Comments for Planning Application 24/00171/OUT

Application Number: 24/00171/OUT

Address: 24 High Street Cullompton Devon EX15 1AA

Proposal: Outline for the erection of a dwelling with some matters reserved and additional parking for No 24 High Street

Proposed Site Plan
scale 1:200

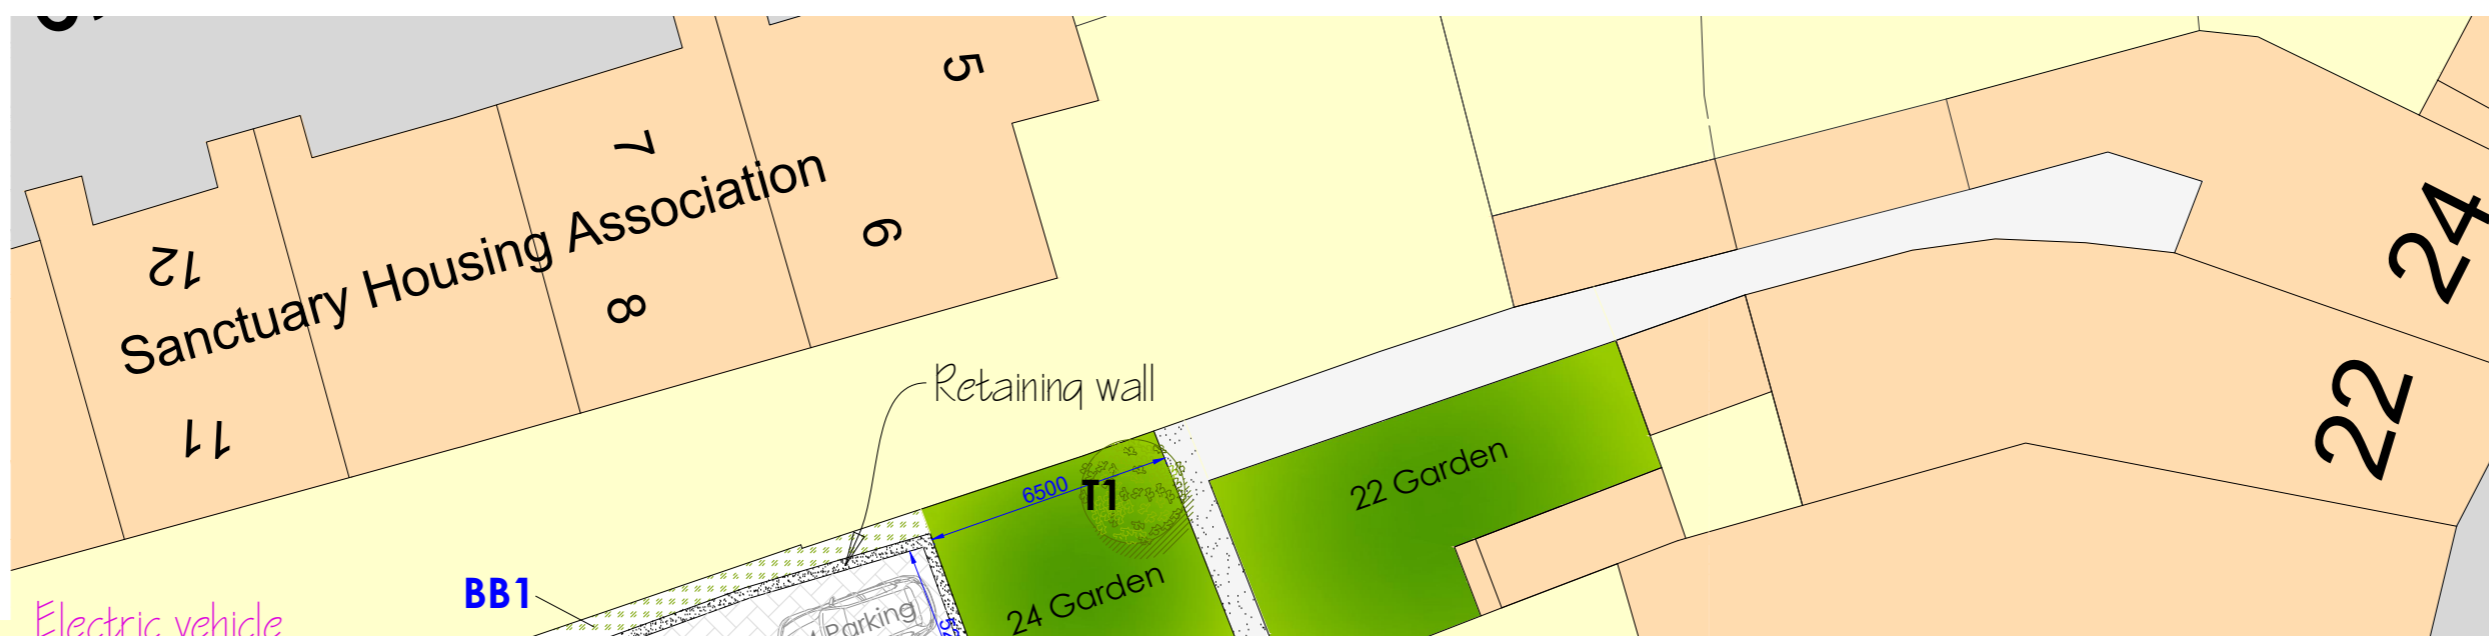
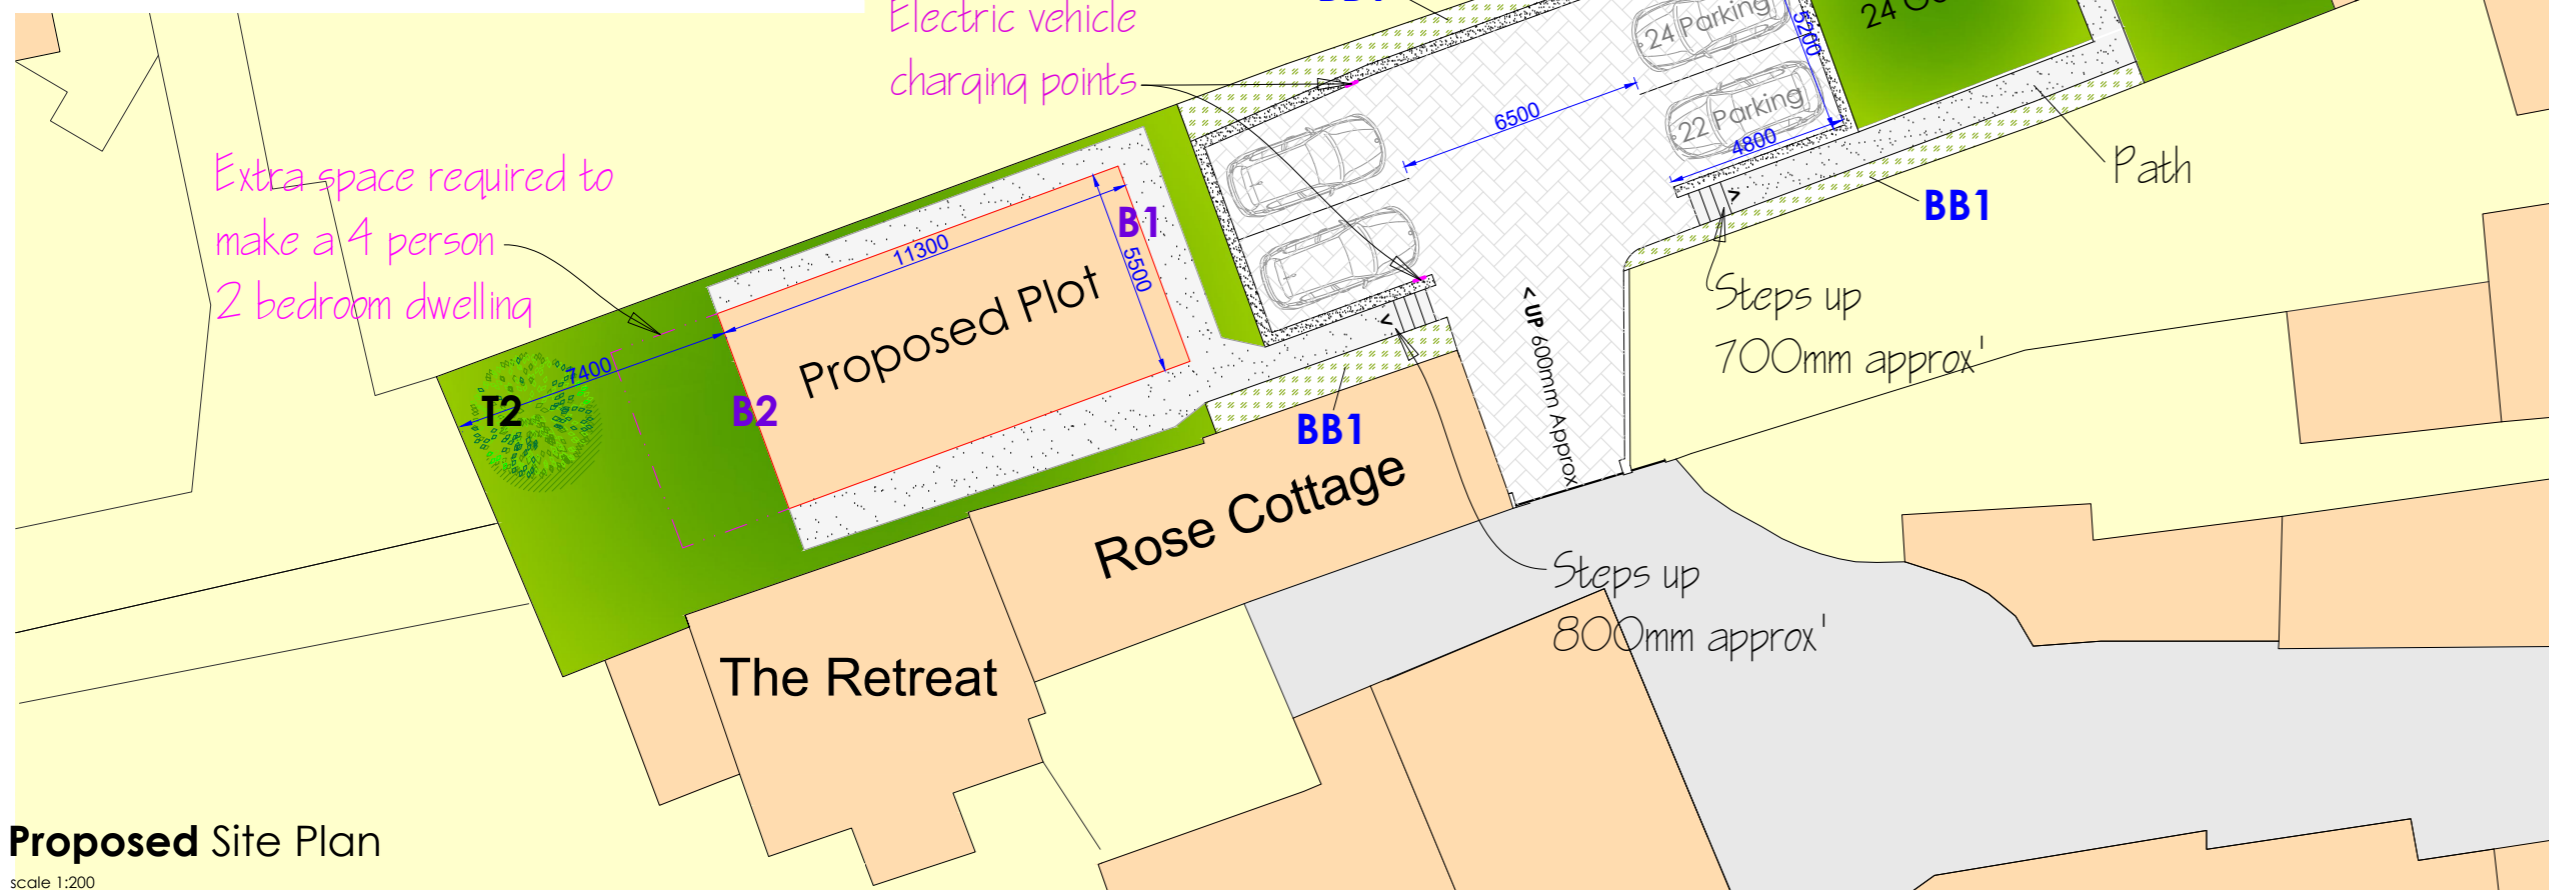
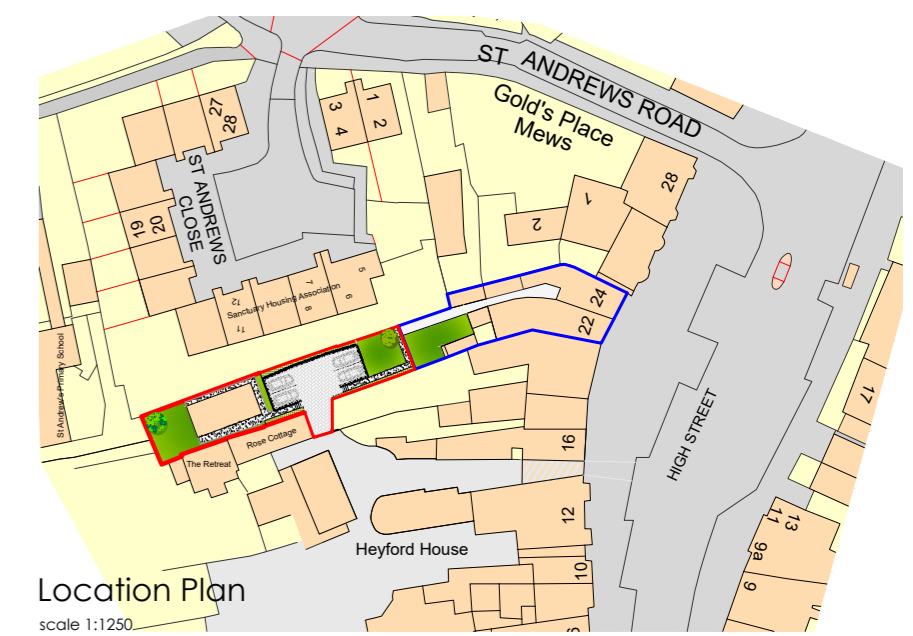
Comment: The plan as presented, would block the light to our kitchen window and as such we would strongly object. The whole building would be in such close proximity to our house, as to make the underpinning of our foundations essential before any work was started, along with extensive drainage work to deal with the run off. Access is over a private driveway and with water and gas utilities under that driveway it would need to be strengthened and resurfaced as part of any building plan. The area in front of the garage is not owned by 24 High Street and is used for parking, the nature of that access is not such as to be guaranteed. It is also the narrowest point and both we and our neighbours have pedestrian access across the front of the garage and any further ingress and egress would prove hazardous.
